# Comments for Planning Application 23/03127/HOUSE

Application Number: 23/03127/HOUSE

Address: Bramble Cottage Bluebell Farm Church Street Seal Sevenoaks Kent TN15 0AR

Proposal: Updating the location of two of the allocated spaces to reflect the as-built location.

# Proposed Site Plan

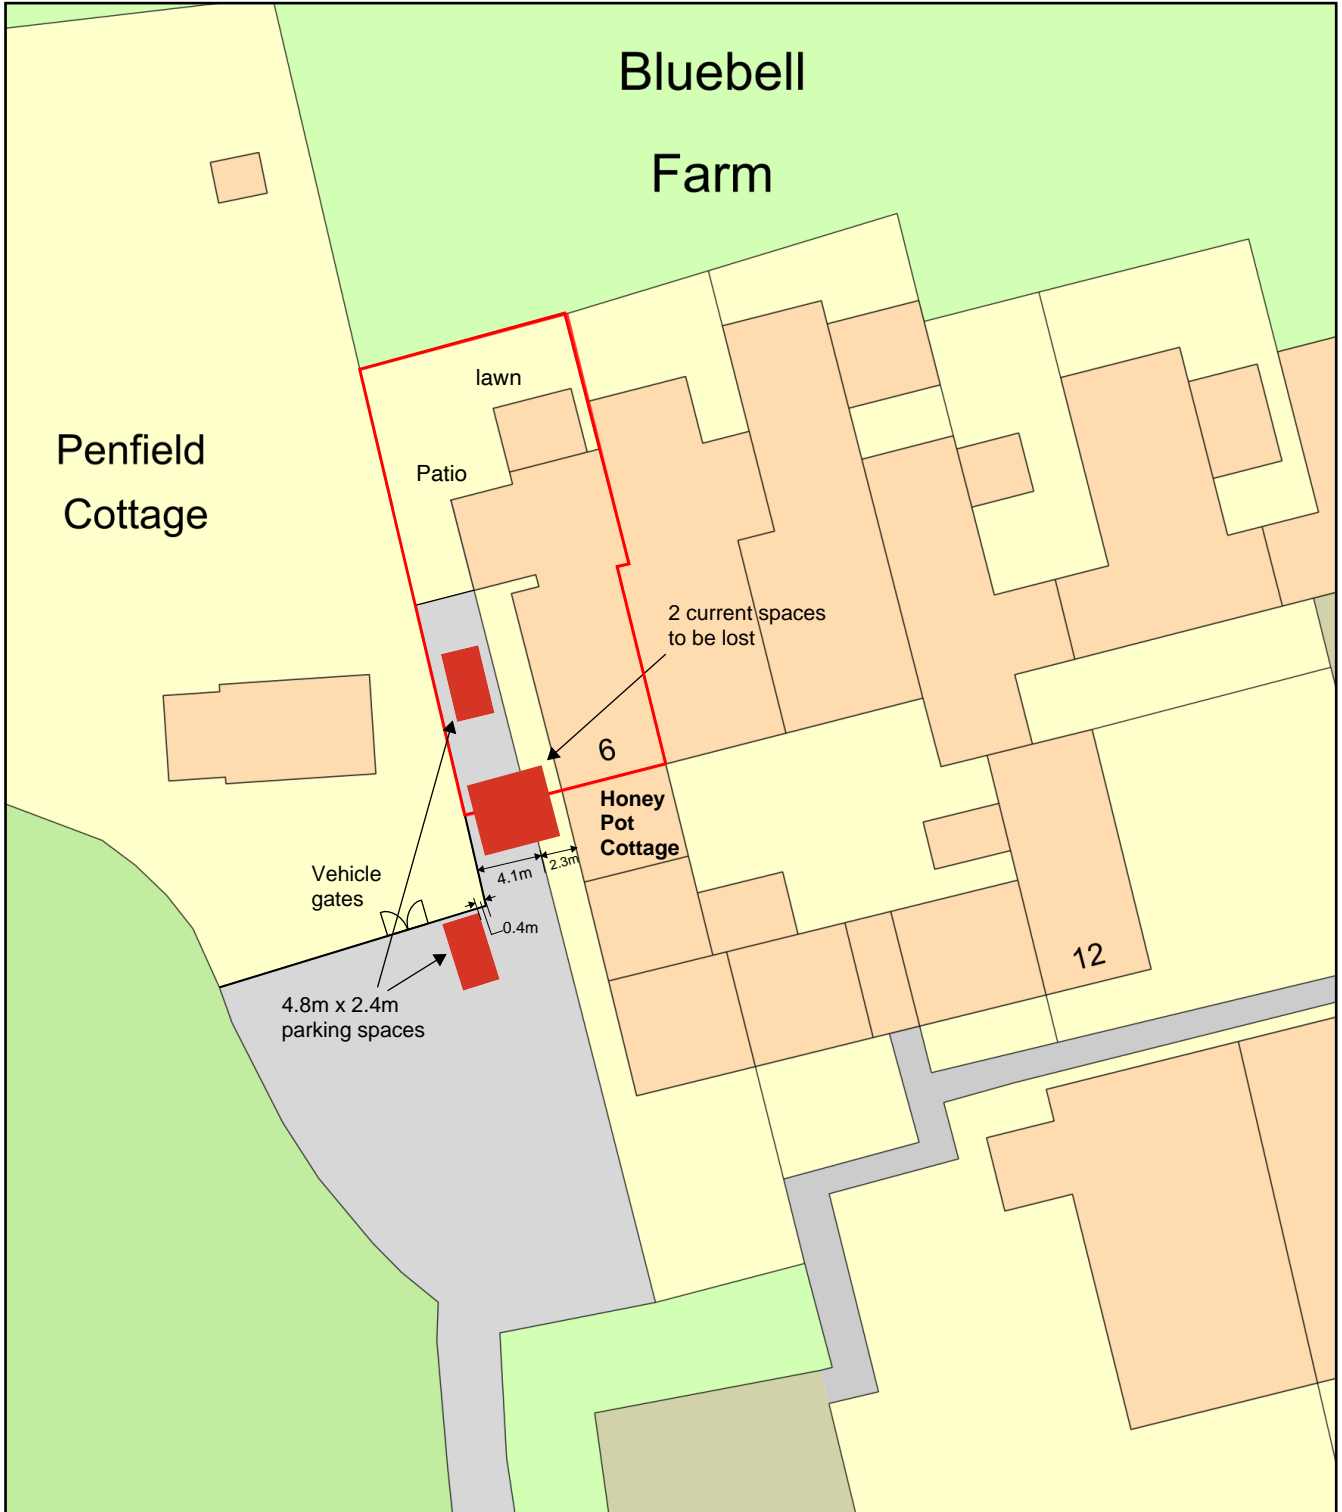
Comment: I would like to object to this planning application to relocate a car parking space from the private driveway of Bramble Cottage to directly in front of the neighbouring property [REDACTED] [REDACTED] restricting the outlook and privacy from the property and disrupting the openness of the farm within the green belt and an AONB. The National Planning Framework Policy deems development appropriate if it does 'not have a greater impact on the openness of the Green Belt than the existing development'.

In moving the space, it not only restricts access for larger vehicles by narrowing the space available, it will also limit/disrupt access for emergency vehicles. See photographs 1 & 2 attached. Please also note, the error on the drawing submitted by the applicant, indicating [REDACTED] is set further north from the proposed parking space. Property boundary is the blue line on photograph 3 attached.

The distance of the proposed car parking space from [REDACTED] is 4.25m from the property boundary and 6.5m from the front door. The distances referred to in application 23/01736/HOUSE on Bluebell Farm, are considerably more and at least 3 times further from the property boundary; approximately 20m.
